From: Stephen Gee [REDACTED]
Sent: 04 May 2021 07:54
To: James Cross <James.Cross@arun.gov.uk>
Subject: BN/135/20/PL - Boweries, Barnham Road

Following the completion of the designers response and the additional highway information provided (and hosted on the planning portal) I can offer the following recommendation to planning application ref BN/135/20/PL

No objection subject to the following S106 and conditions.

title
**PROPOSED DEVELOPMENT - PHASE 1 & PHASE 2
CYCLEWAY TIE-IN AND SIGNAGE**

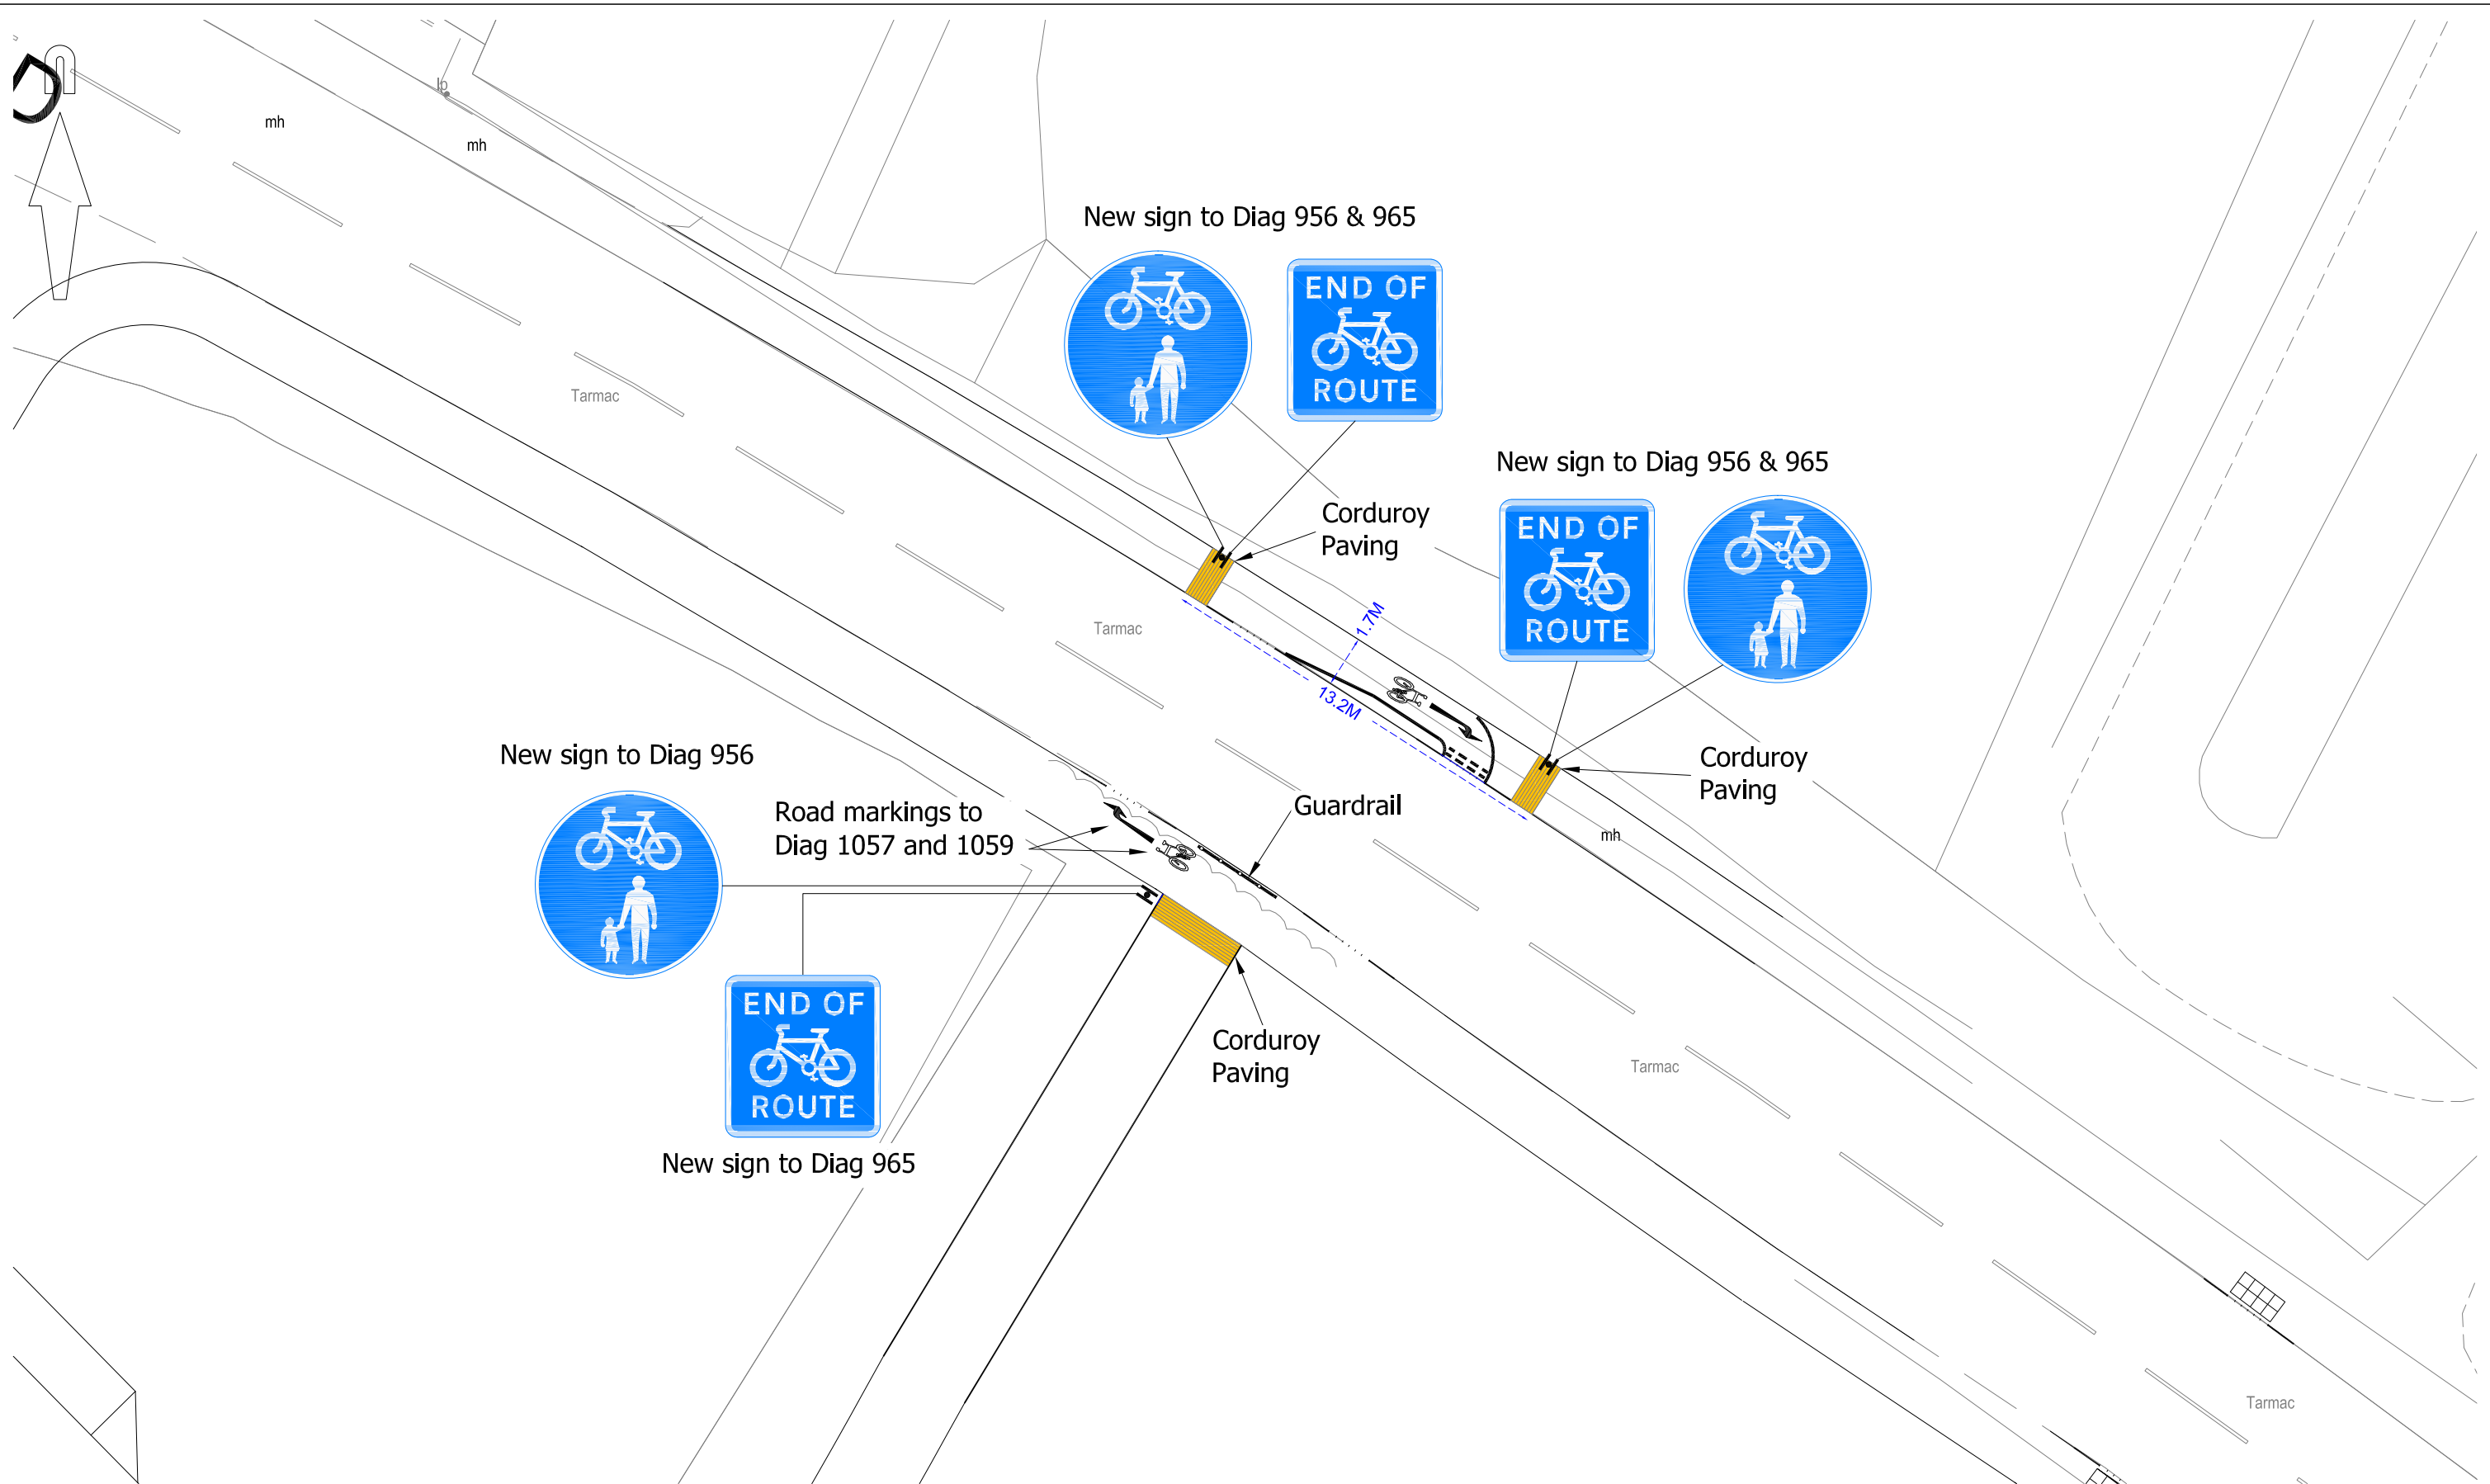
No part of the development shall be first occupied until such time as the cycle access serving the development has been constructed in accordance with the details shown on the drawing titled proposed development – phase 1 and phase 2 Cycleway Tie-In and signage and numbered MBSK210326/01.
